Please ask for: Nicola Moore
Email: nicola.moore@arun.gov.uk
Telephone: Ext 37944
Our Ref: EP/18/22/CLP
Your Ref:
Date: 21st February 2022

Lawful Development Certificate for a Proposed Use or Development

Development: Lawful development for the proposed replacement of existing conservatory with a single story rear extension projecting 4m.
Location: 42 Normandy Lane East Preston BN16 1LY

TITLE:
Proposed Plans

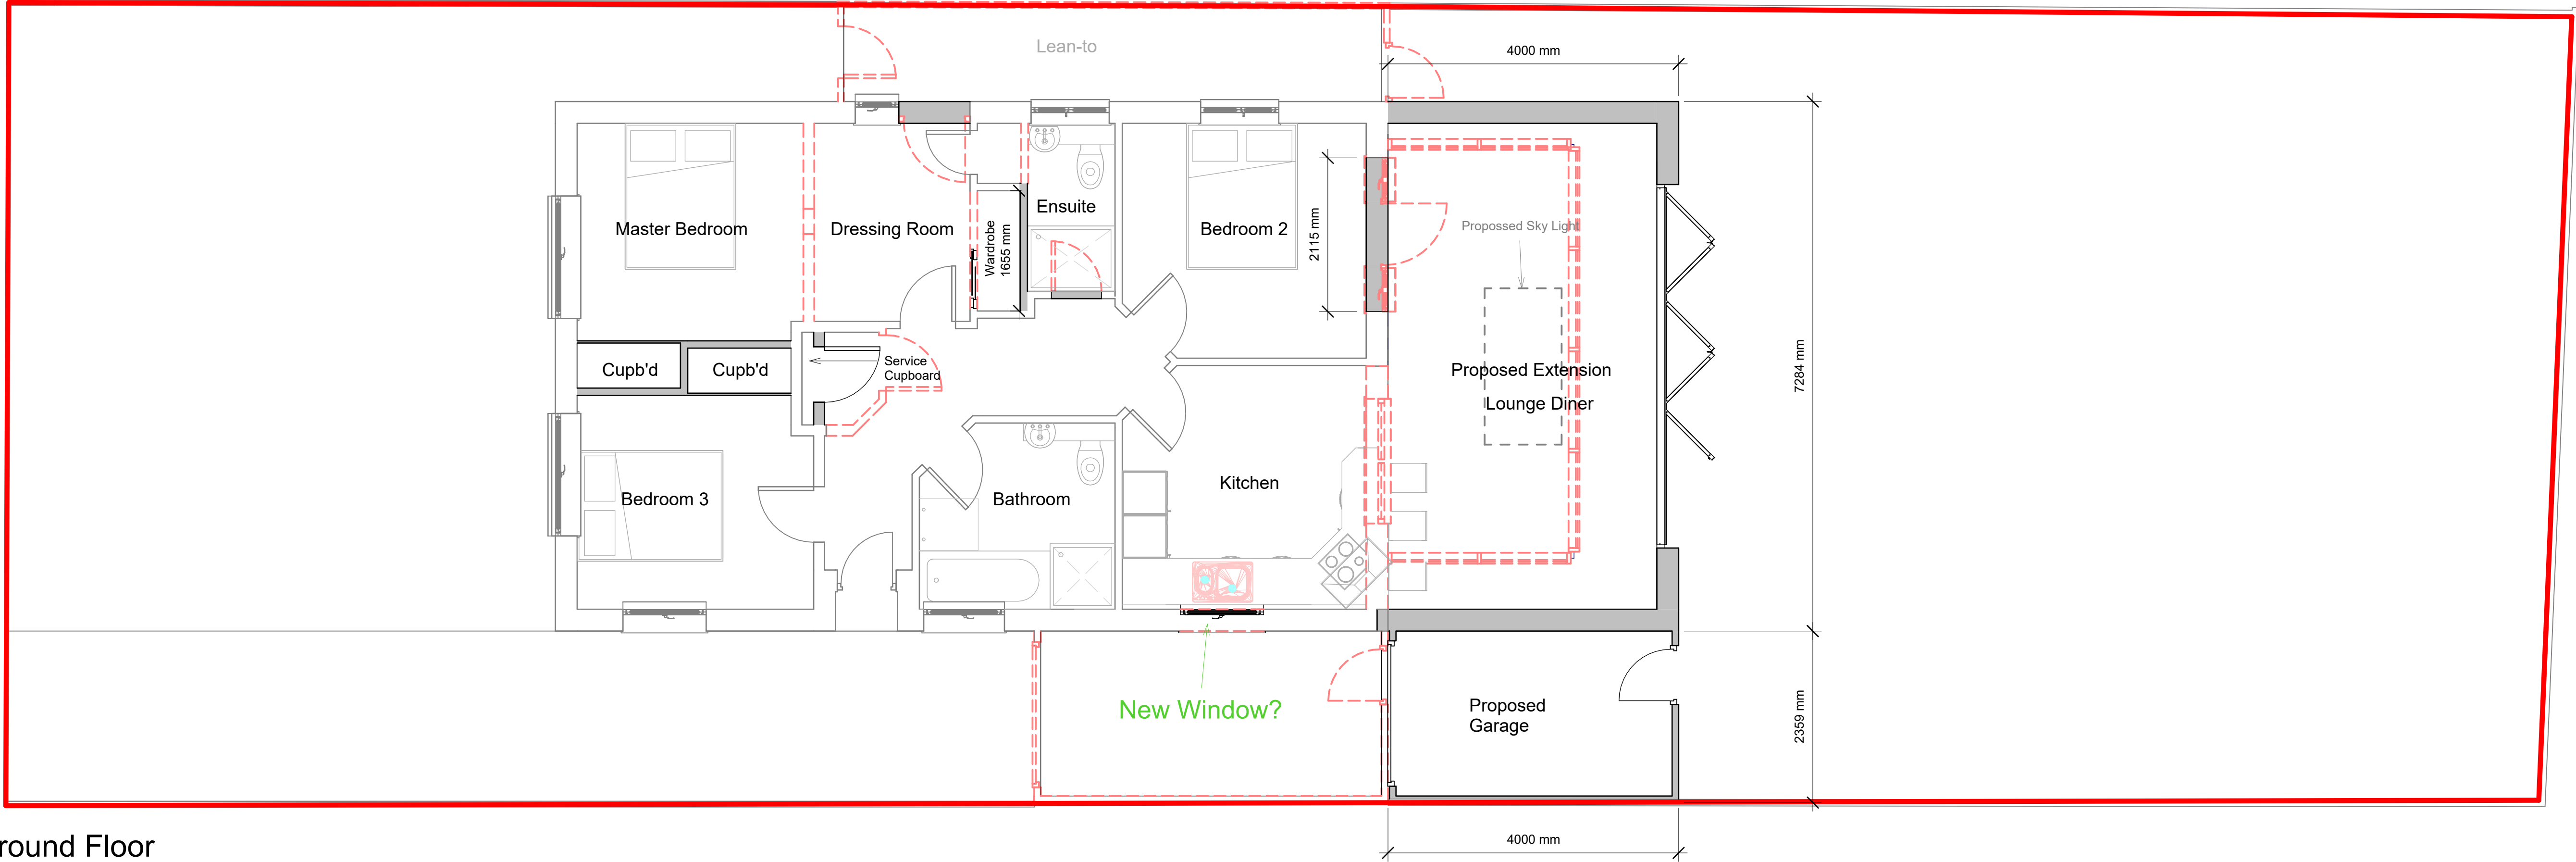
The Proposed floor plan includes a proposed garage. For clarity, please confirm if this is to be included in this application.

TITLE:
Existing Floor Plans

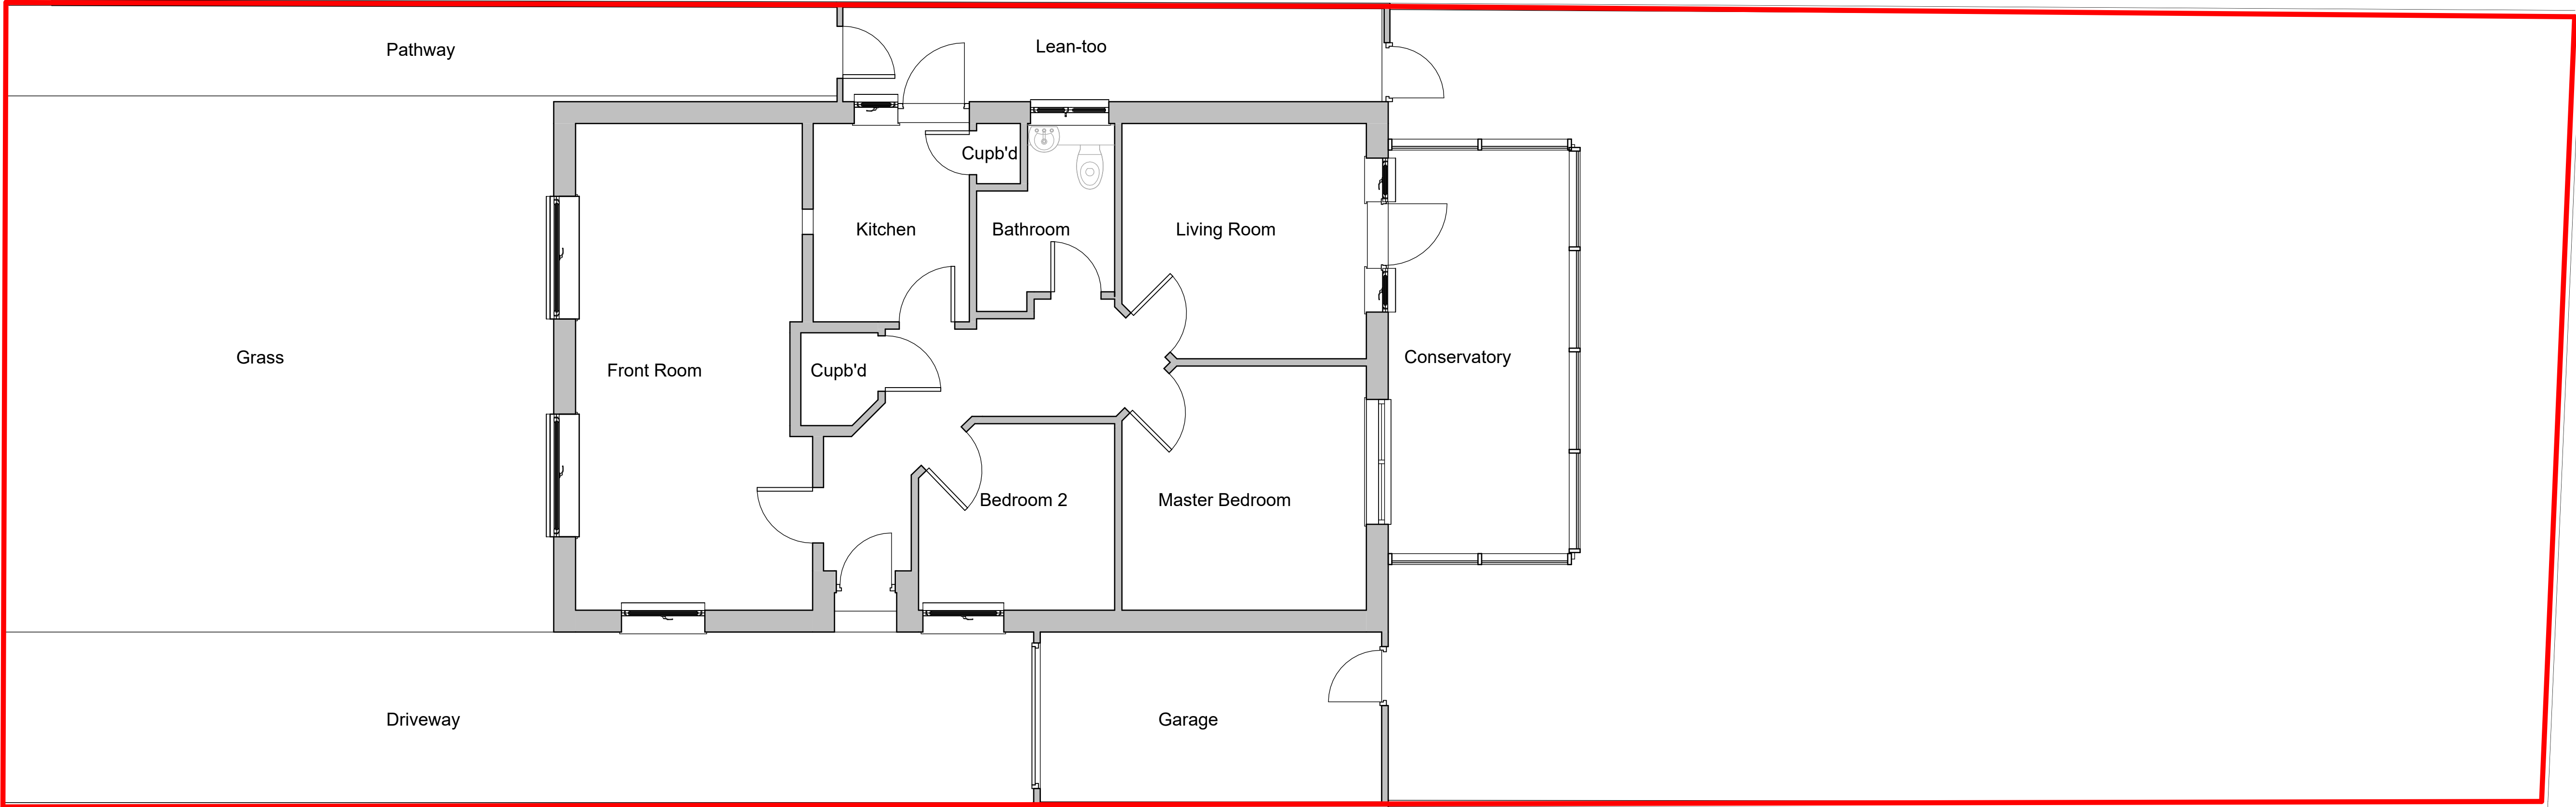
Please submit electronic plans in pdf format clearly labelled existing floor plans at a scale of 1:50 or 1:100. Further details can be found in the Validation Requirements List.
